CITY OF ALBUQUERQUE

Re: Murphy Oil
100 Eubank Blvd NE
Traffic Circulation Layout
Engineer's Stamp 09-14-2020 (L21-D059A)

Based upon the information provided in your submittal received 10-22-2020, the above referenced plan cannot be approved for Building Permit until the following comments are addressed:

SHEET NO.
C-8

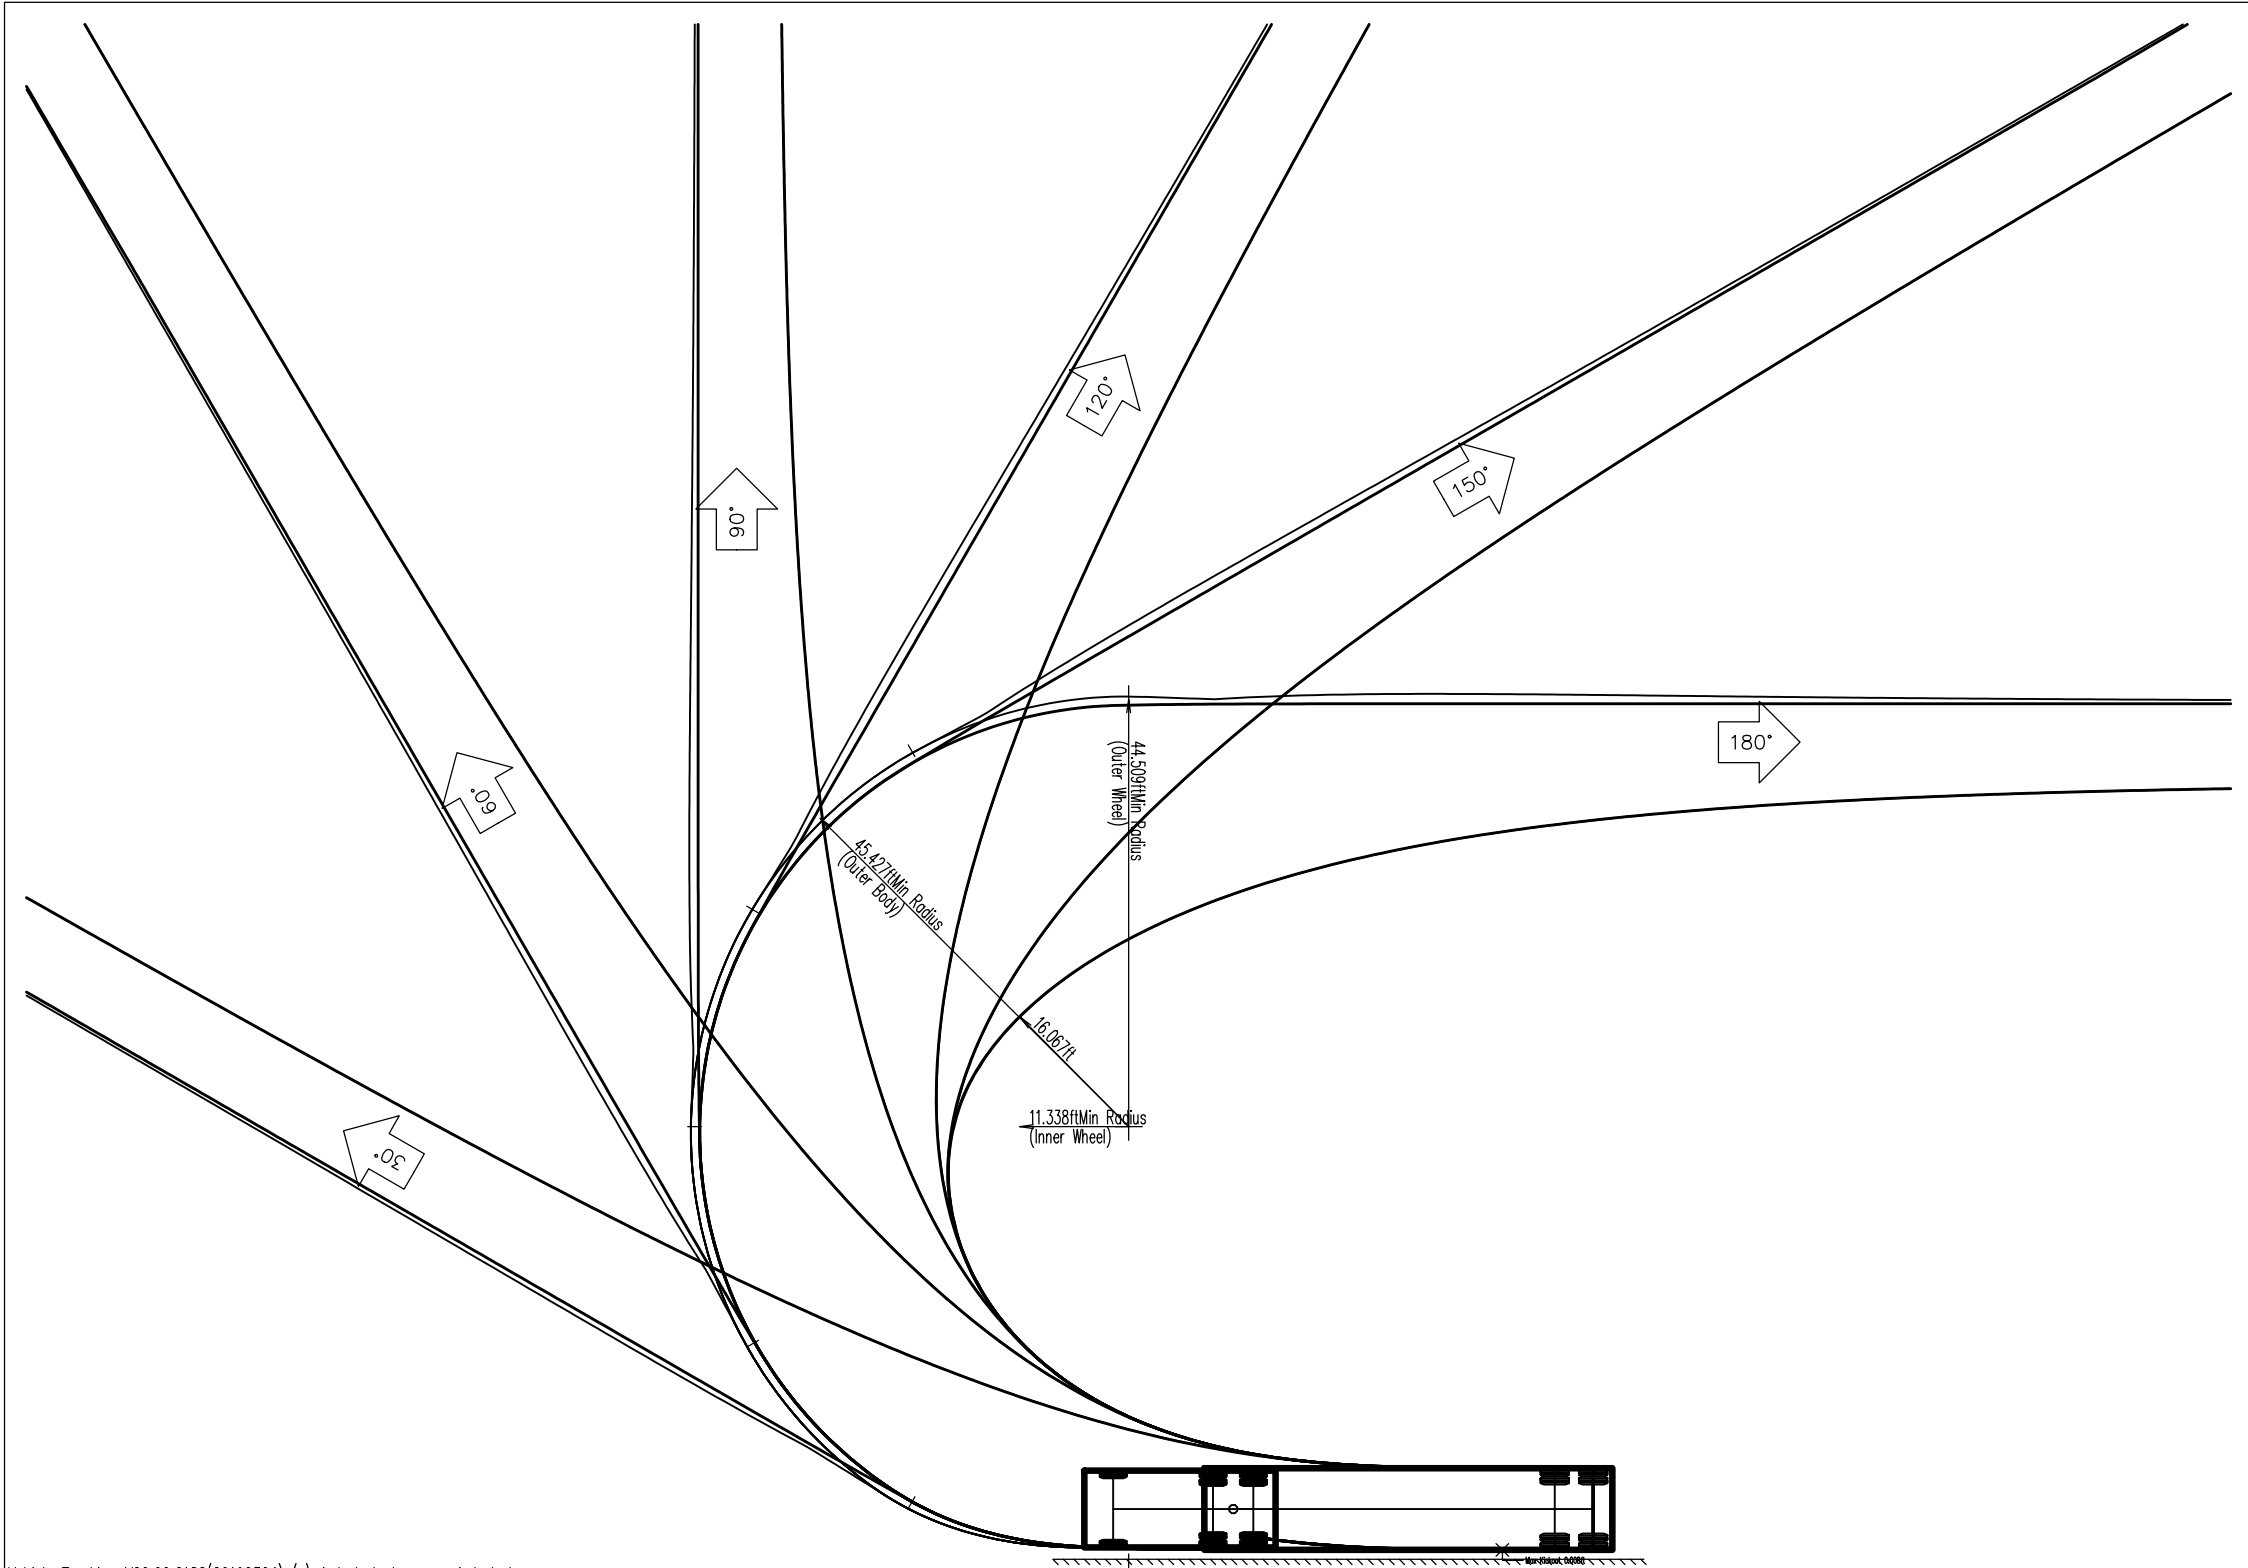
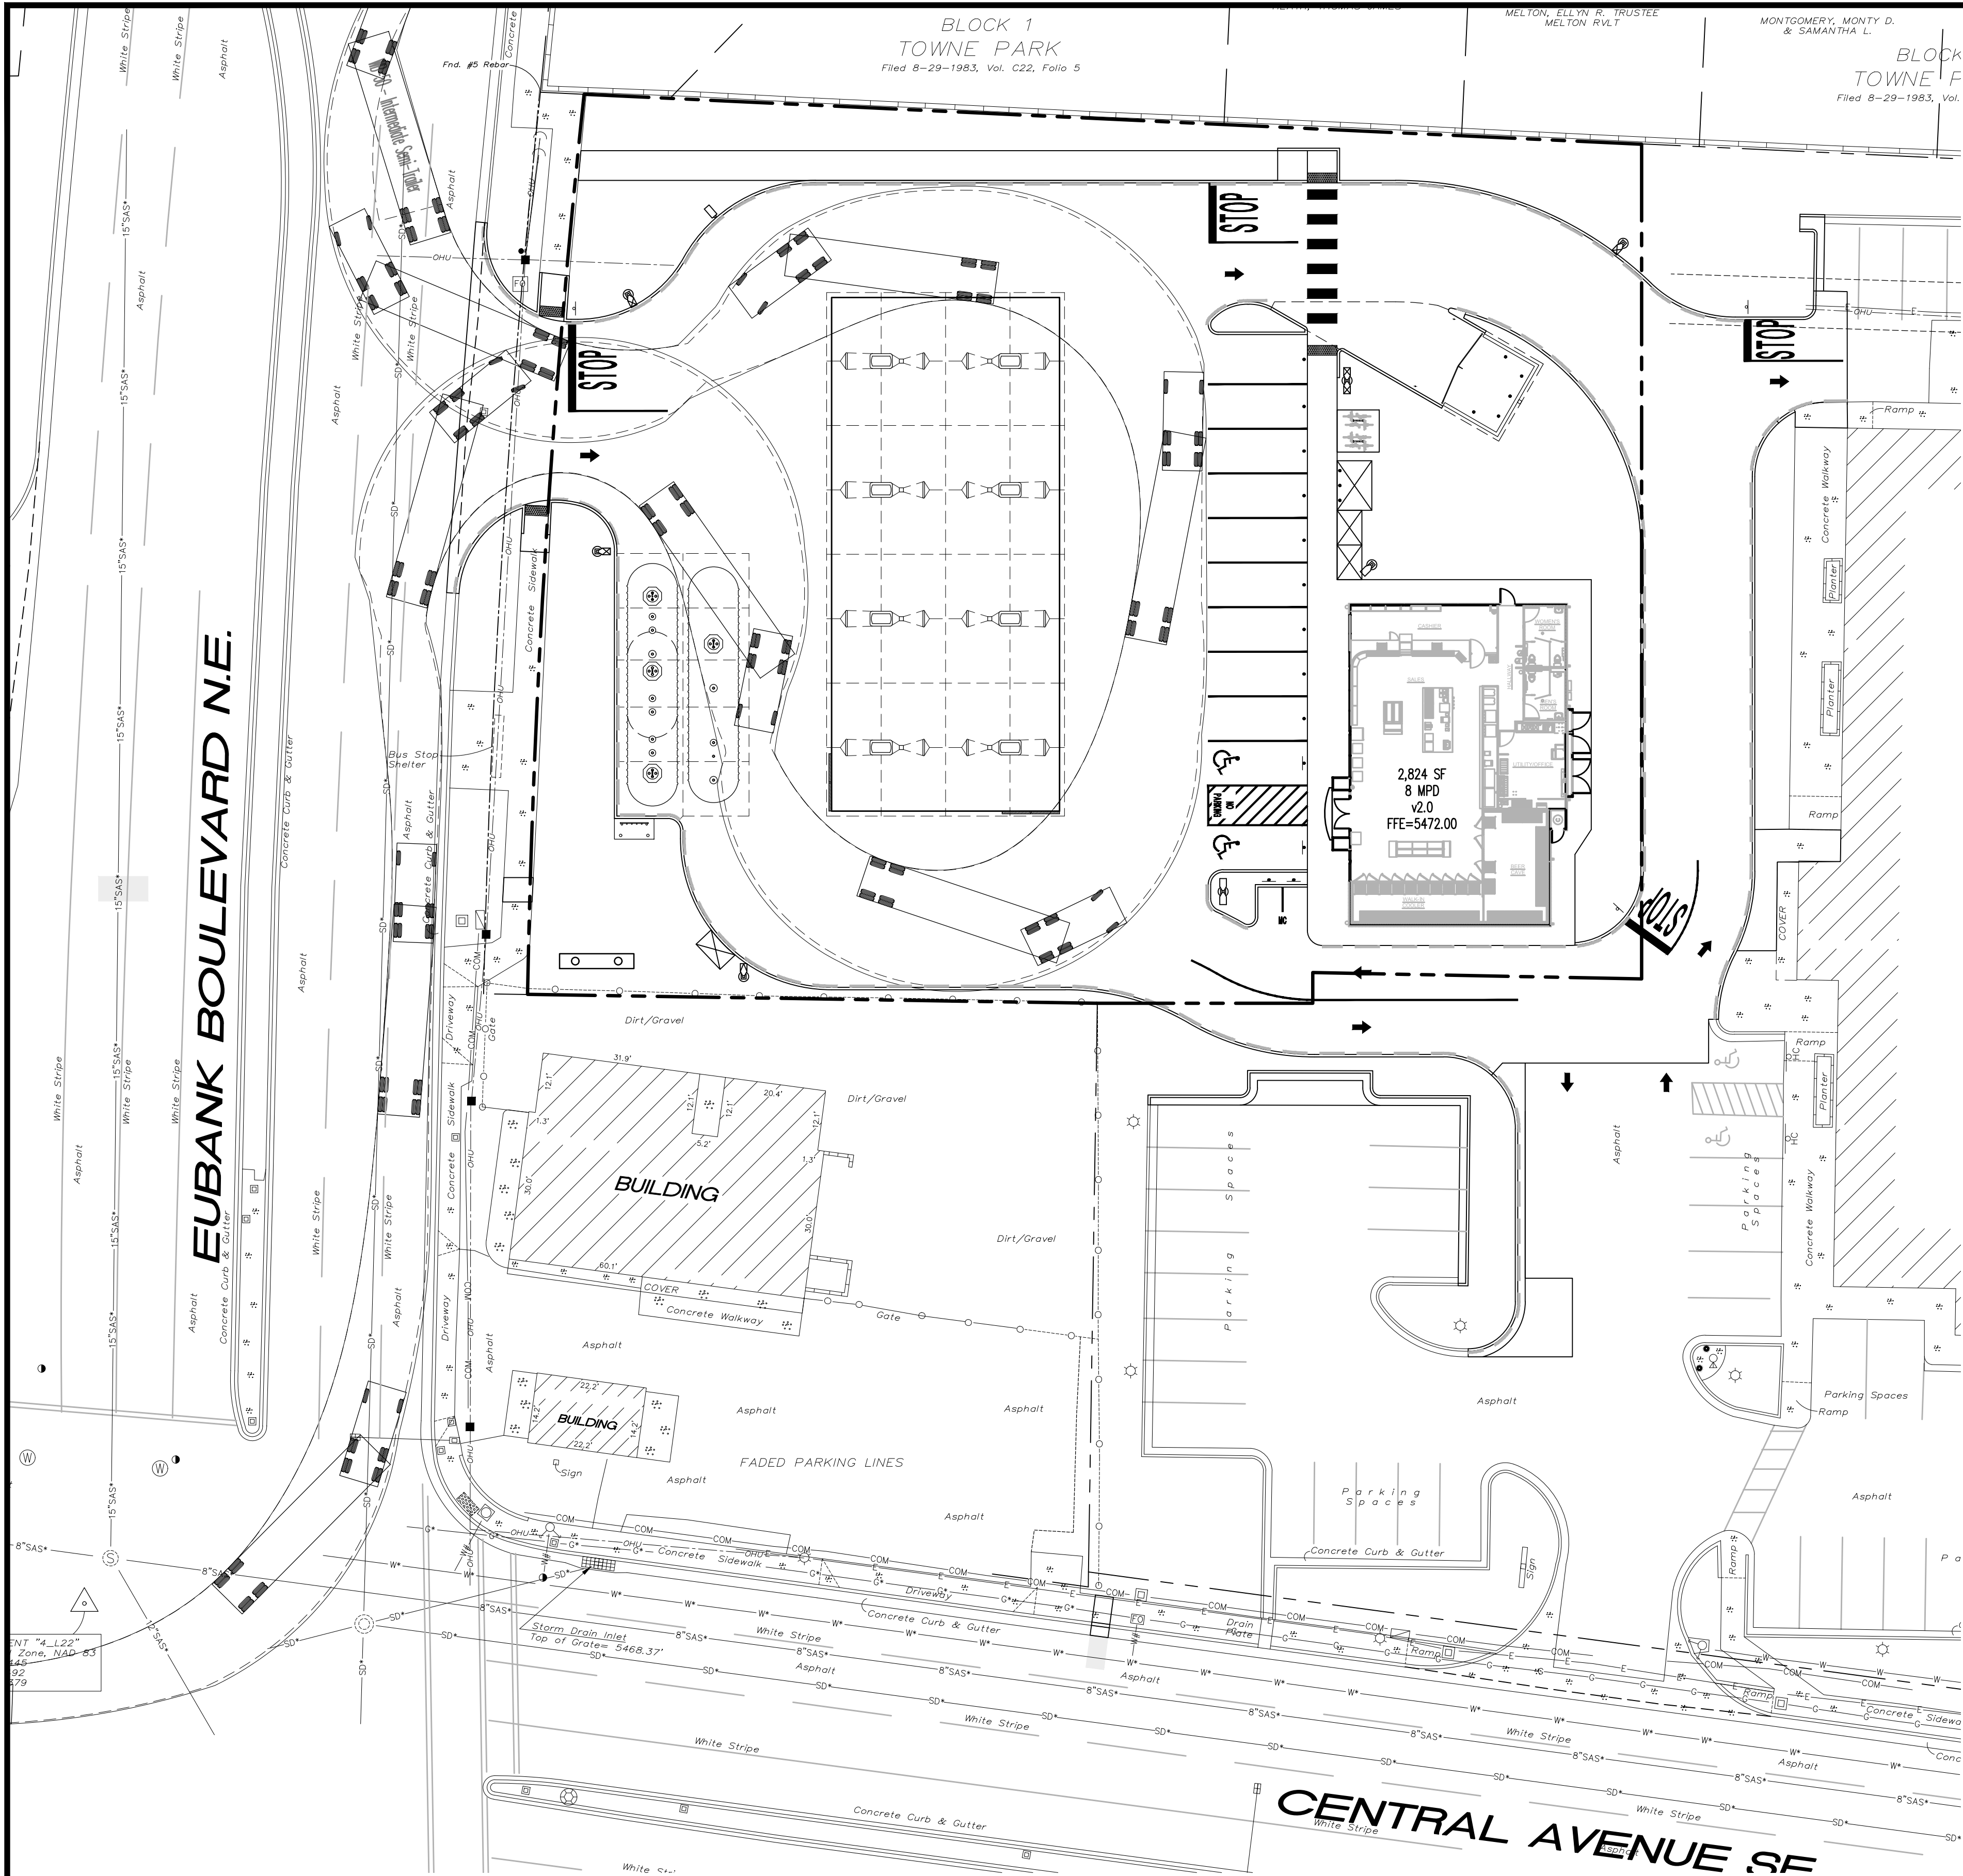
14. List radii for all curves shown; for passenger vehicles. **Radius for delivery trucks, fire trucks, etc. is 25 ft. or larger.** Verify the existing/proposed smaller radiuses are an issues around the driving aisles (**turning templates would be sufficient for verification**).
